Our ref: HA/2015/117383/01-L01
Your ref: BN/29/15/PL
Date: 27 August 2015

SOLAR PARK INCLUDING THE ERECTION OF SOLAR ARRAYS, INVERTERS, TRANSFORMERS, EQUIPMENT HOUSING, SECURITY FENCING, INTERNAL TRACKS, ANCILLARY EQUIPMENT & ECOLOGICAL MITIGATION. THIS IS A DEPARTURE FROM THE DEVELOPMENT PLAN LAND AT BARNHAN COURT BARNHAM

Environment Agency Position

FIGURE 13
Typical panel elevations

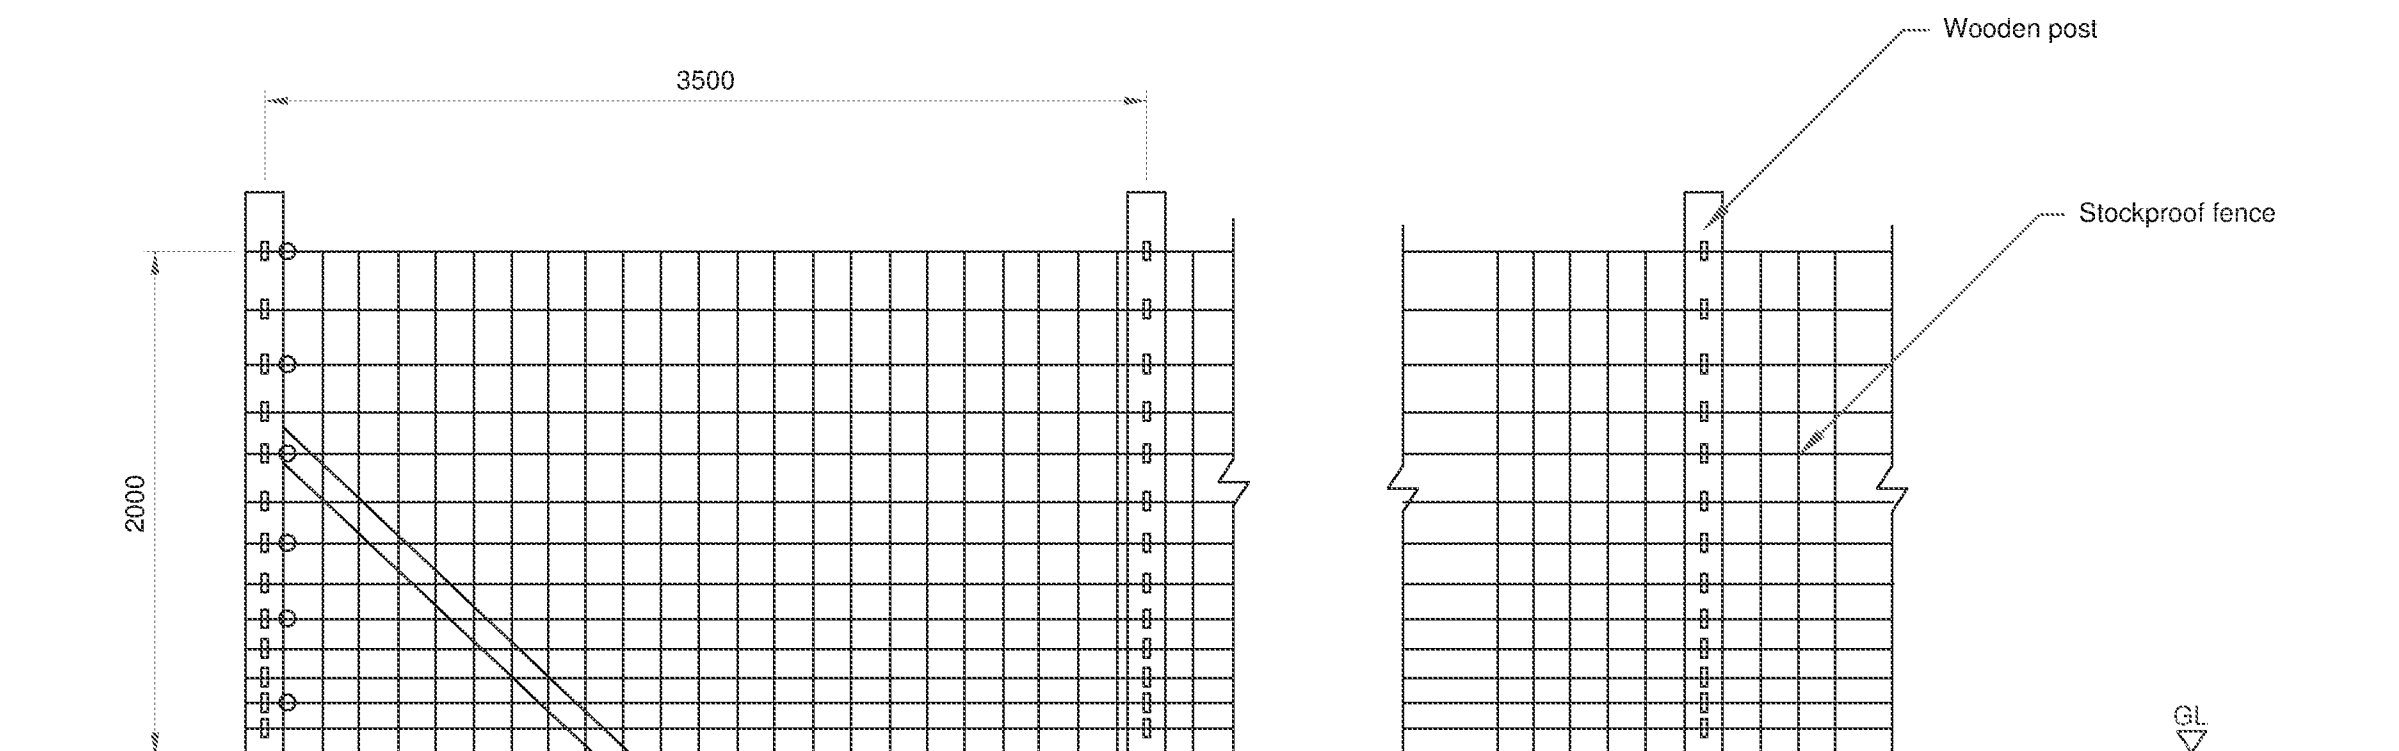
We advise that solar panels are erected 300 mm above the 1 in 200 year plus climate change level (minimum height of 4.74m above Ordnance Datum (AOD). This is opposed to the proposed level of just 2500 mm above existing ground level (around 3.5mAOD) as indicated in Drawing number 2768_04 (Typical Panel Elevations).

The development hereby permitted shall not be commenced until such time as a scheme to ensure no net loss of floodplain storage has been submitted to, and approved in writing by, the local planning authority.
